Subject: RE: AB/120/20/PL and AB/ 121/20/L Old Bank House, 1 High Street, Arundel

Subject: AB/120/20/PL and AB/ 121/20/L Old Bank House, 1 High Street, Arundel

| Title:-      | Proposed Floor Plans                                      |

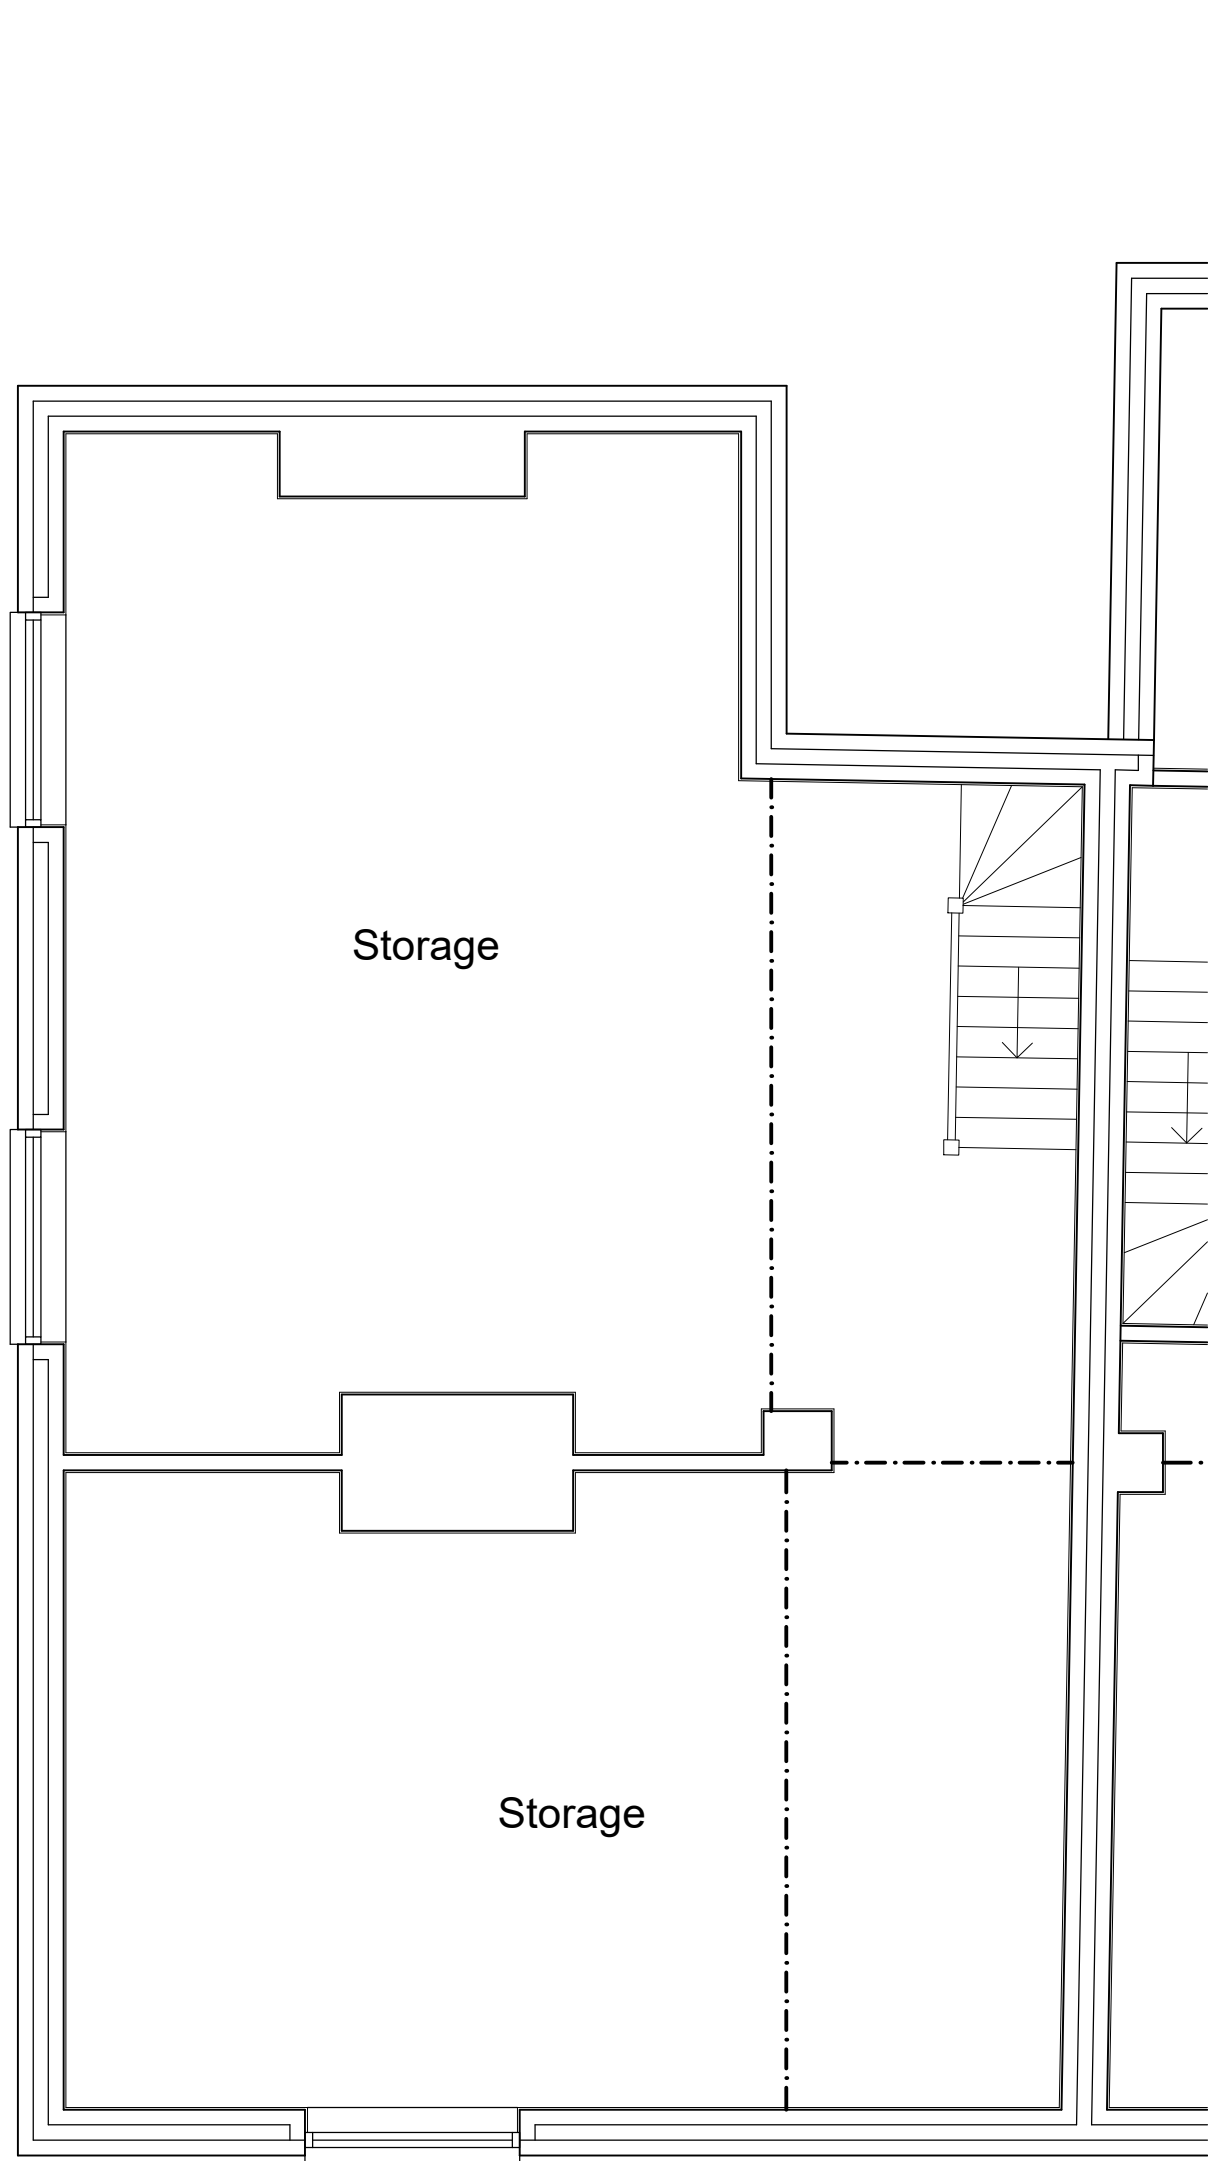
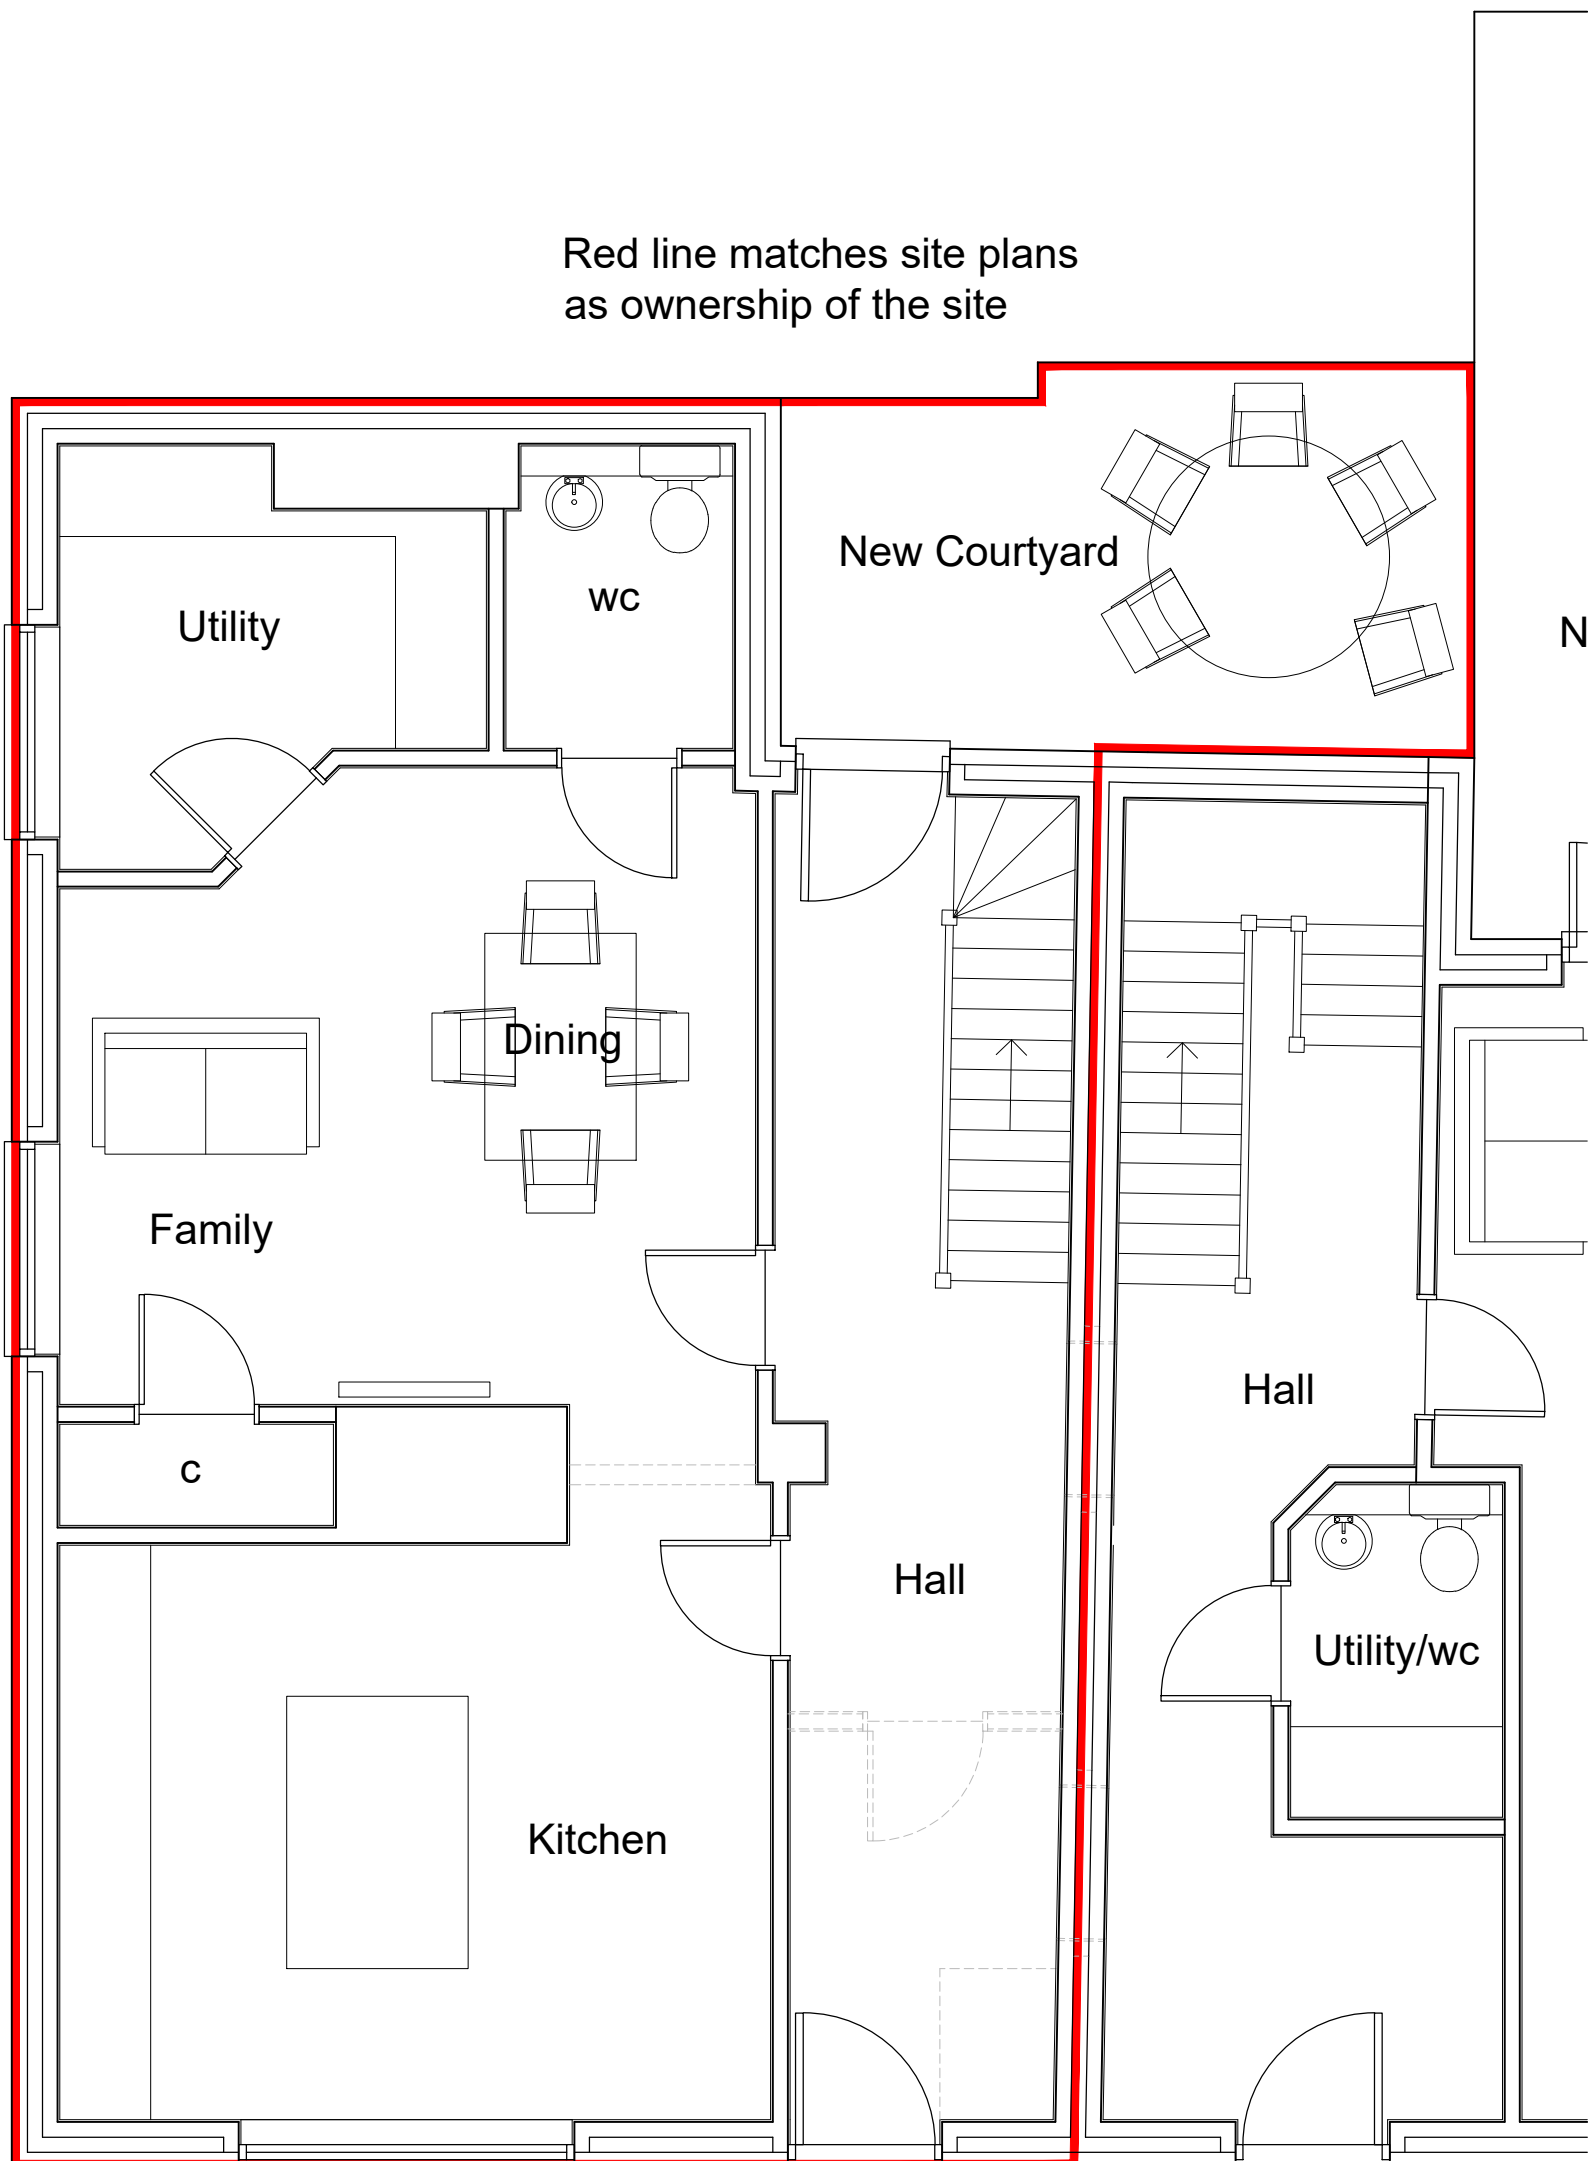
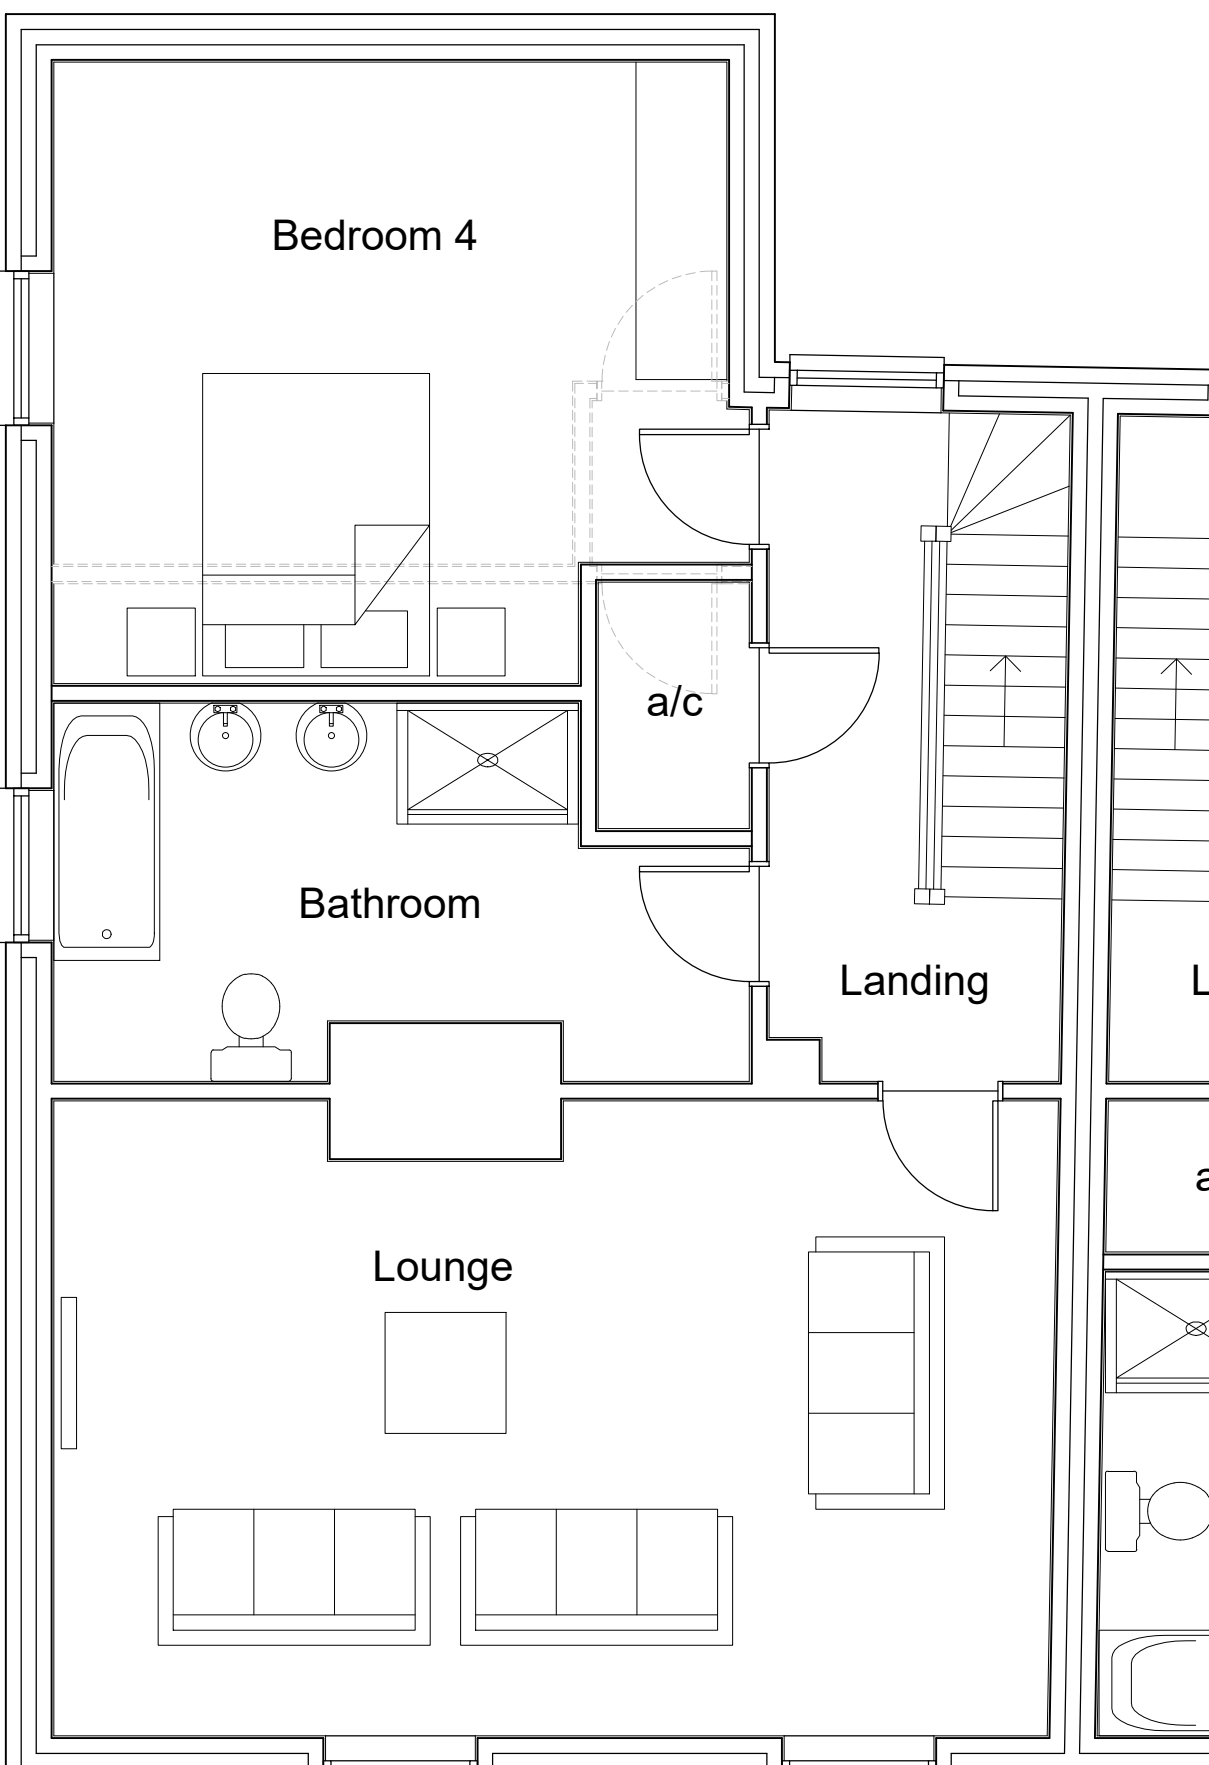
I have been looking at your applications with a view to writing my reports prior to the Christmas break, but I don't think it is going to be possible given the discrepancies in the location/block and floor plans. There is no plan clearly denoting the extent of the rear outside amenity area and the red edge of the application site to the rear of the premises does not appear to tally with the ground floor plan. The shape and projection to the rear do not appear to correlate. Please can you clarify and let me have revised as soon as possible.
